# Submissions Report

Florida Street, Sylvania, State Significant Development

SSD-83258708

29 Florida Street, Sylvania

1 Section 04

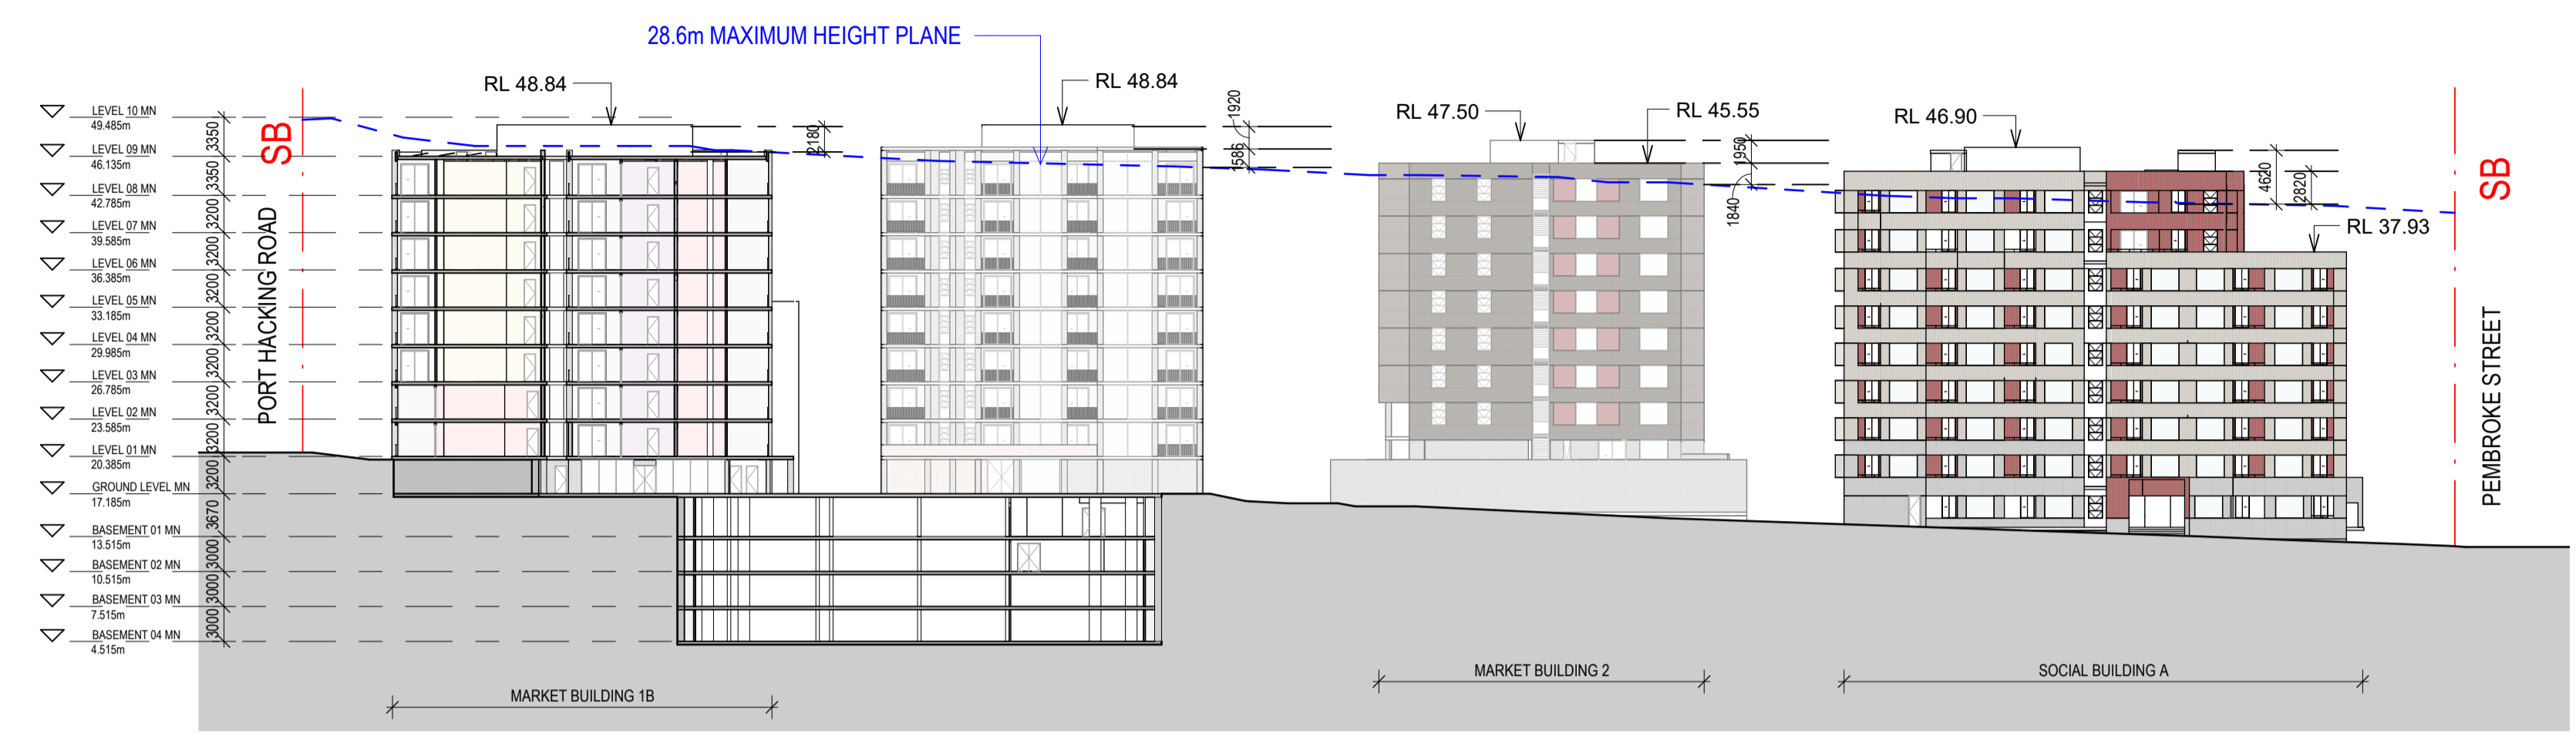
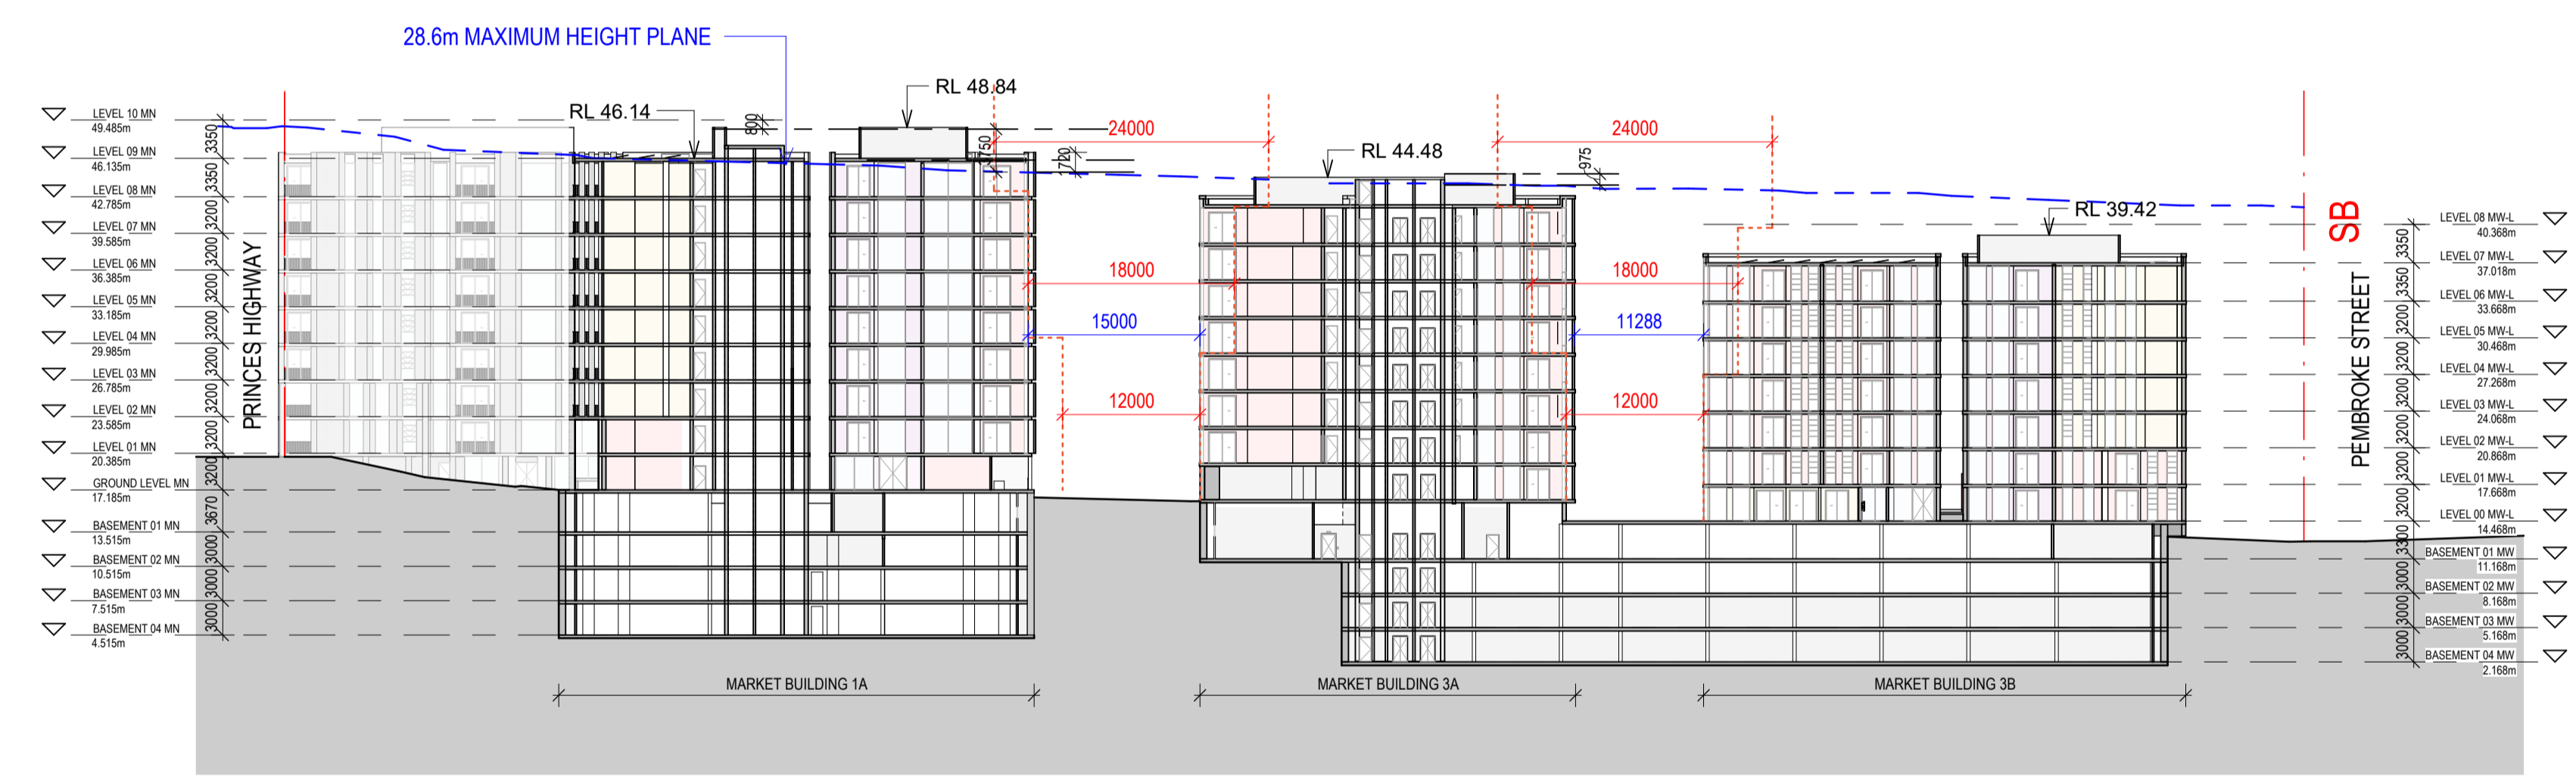
5.1	Provide a schedule detailing where recommended Apartment Design Guide (ADG) building separation distances (i.e. Part 3F) are not achieved and the proposed mitigation measure (e.g., façade privacy screening as outlined in the Architectural Design Report) that are to be implemented to ensure satisfactory visual privacy is achieved.	Refer to the Design Response prepared by BVN at Appendix B which demonstrates the visual privacy objectives of the ADG are achieved.
